Your Ref:  
Our Ref: 21/1983/FUL  
Date: 4 October 2021

### INVALID APPLICATION

**PROPOSAL:           INSTALLATION OF SOLAR PANELS ON FRONT AND REAR  
ELEVATION OF DWELLINGHOUSE**

**LOCATION:            Mayville, 19 High Street, Port William, DG8 9SL**

Dwg: 21-09-02 DD01 A Scale: 1:100 or as shown  
 Date: Sept 2021

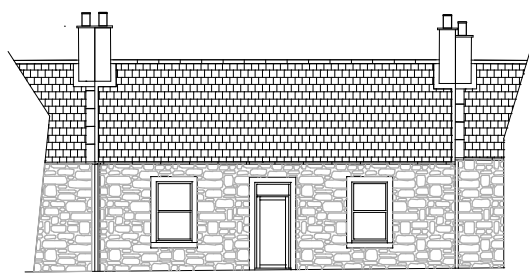
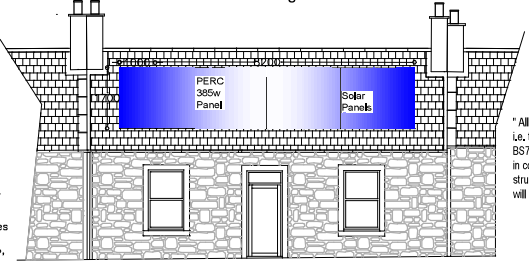
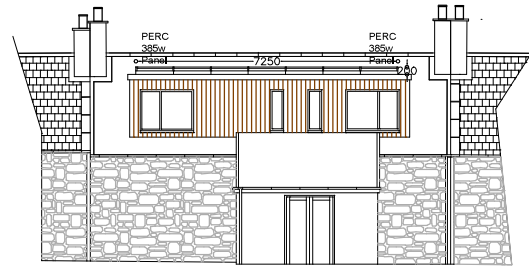
- 01.   Please submit an amended version of your electronic submission with the key dimensions annotated on Drawing number 21-09-02 DD01 i.e. dimensions of the proposed solar panels. (This is required in our guidance notes as PDF files cannot be accurately scaled when viewed online and so written dimensions need to be shown instead).**
